# KITTITAS COUNTY FIRE MARSHAL'S OFFICE

September 20, 2011

Re: Mystic Lands (SG-11-00005)

RECORD OF SURVEY

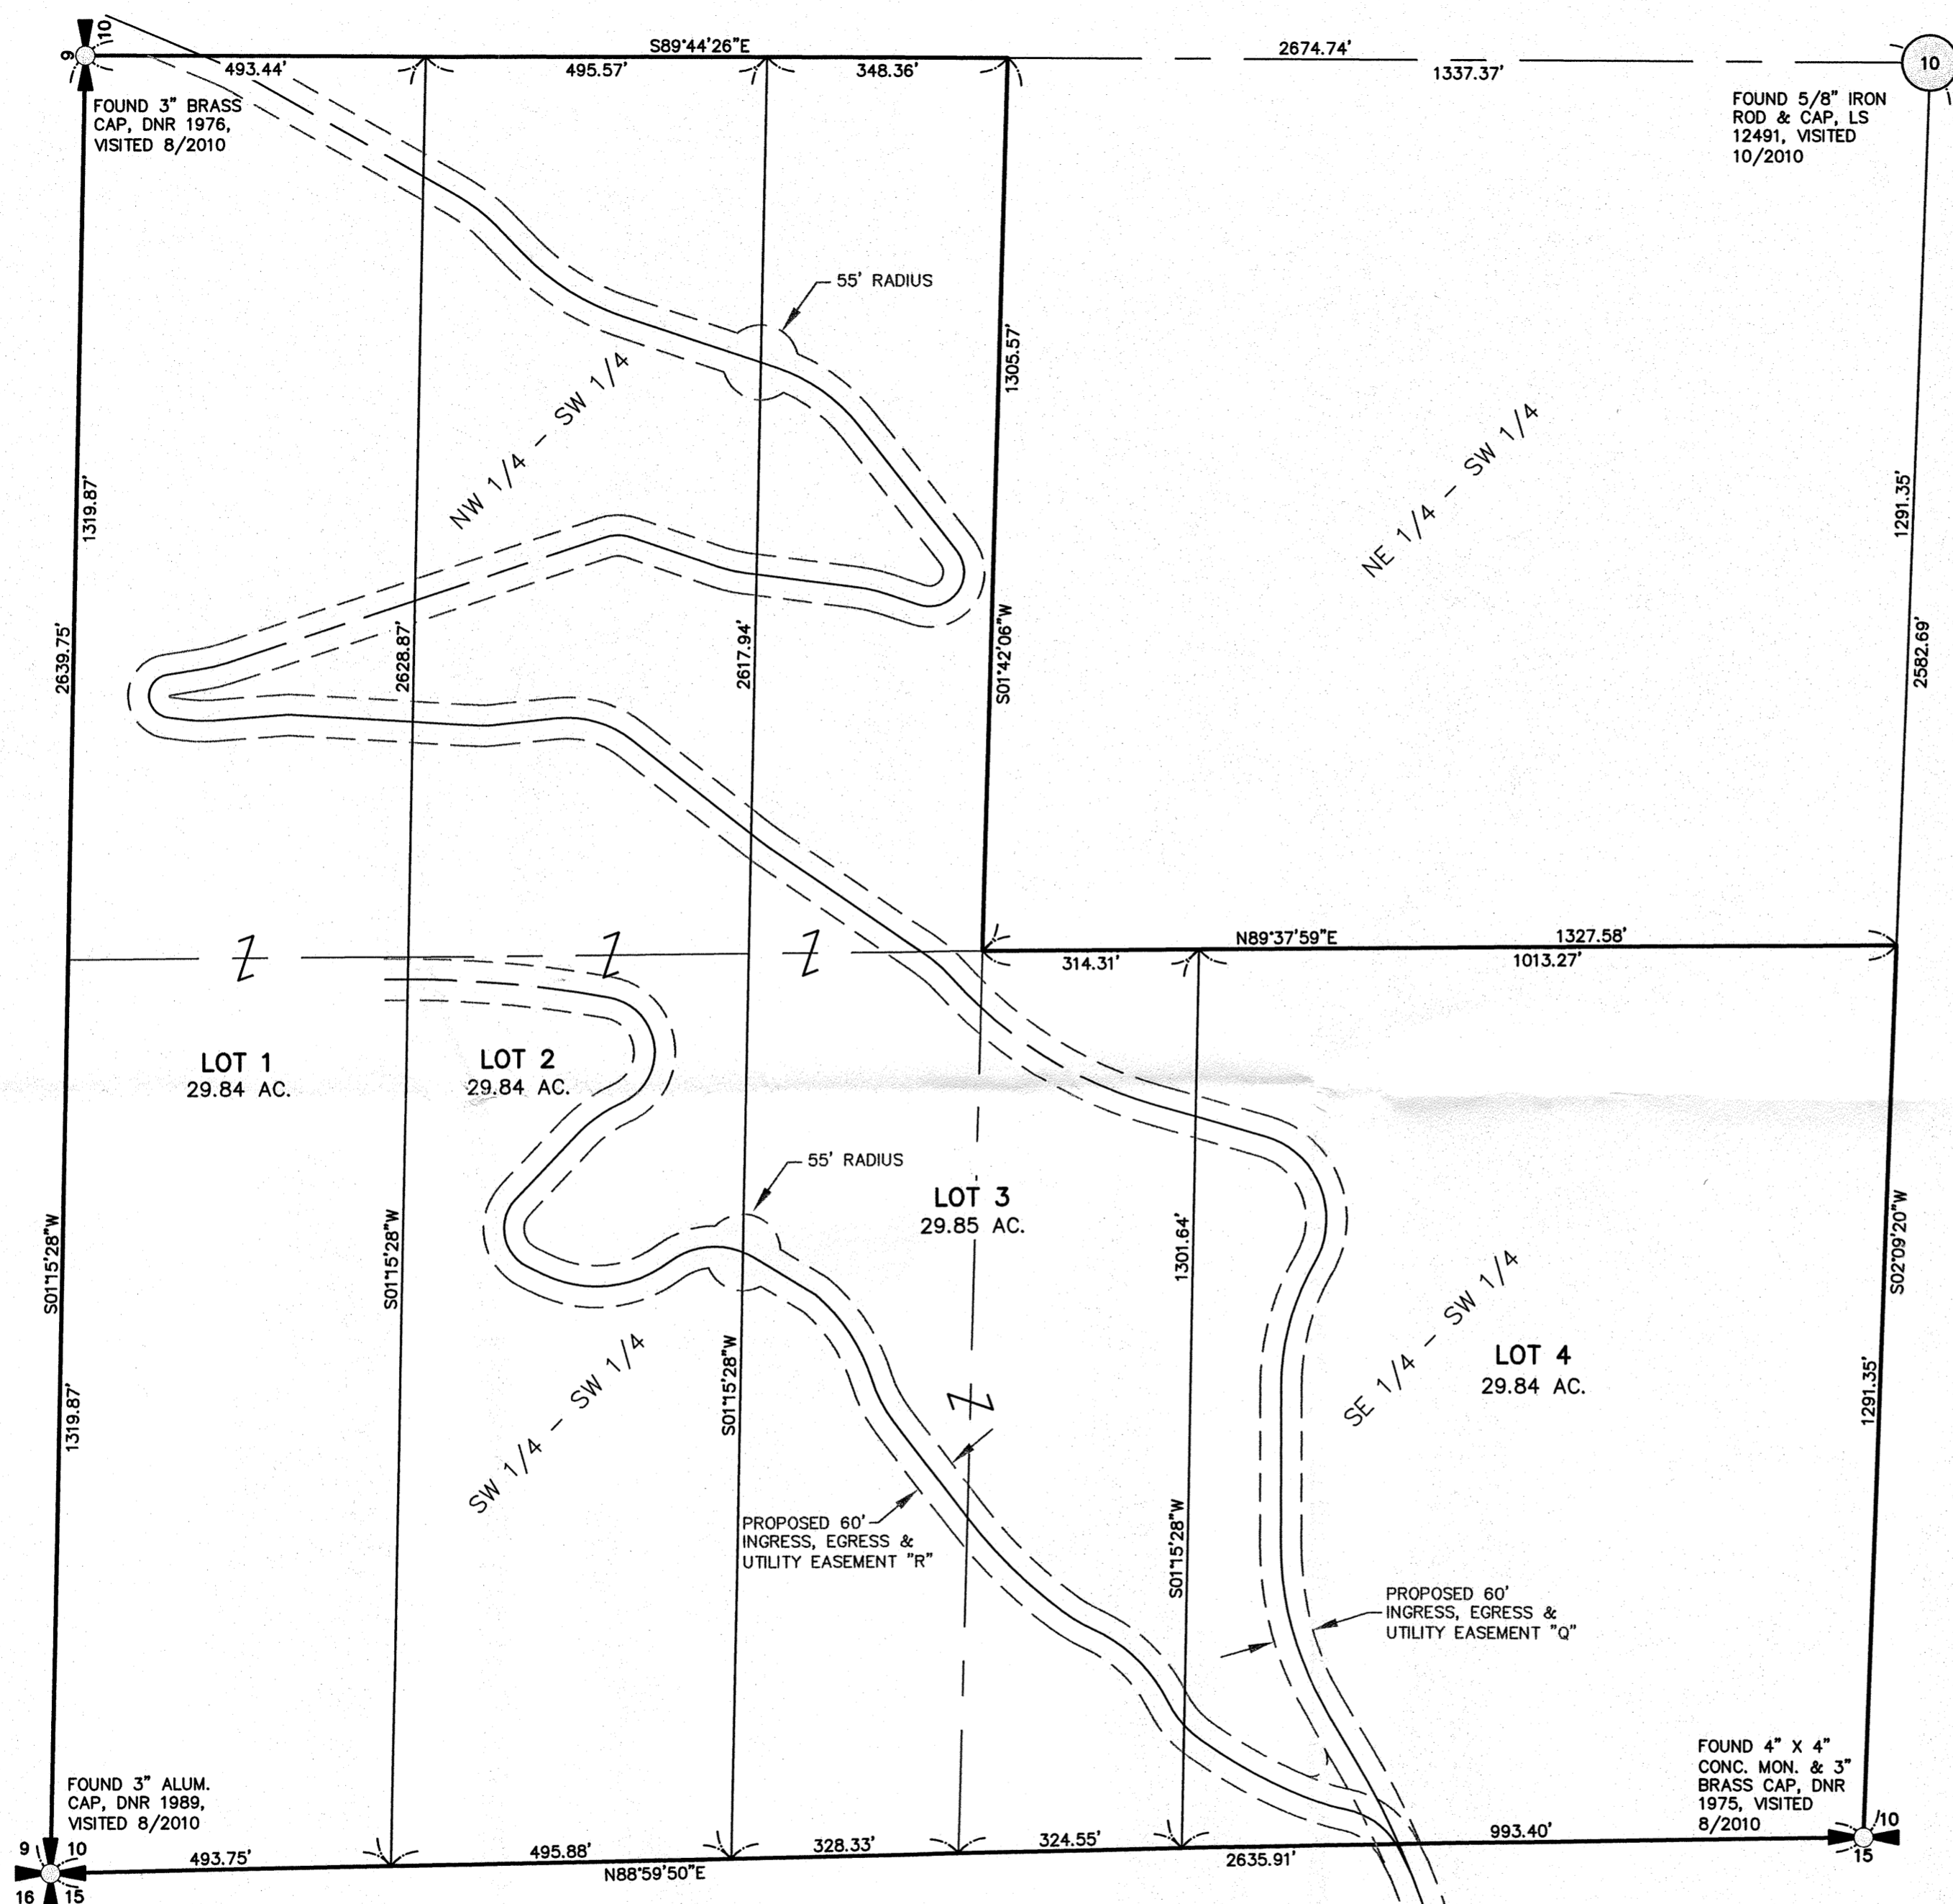
- Ensure that the segregation does not infringe upon existing structures, to include propane tanks, etc.
- Creation of any additional roads or access must comply with the International Fire Code.
- All future development must comply with the International Fire Code.
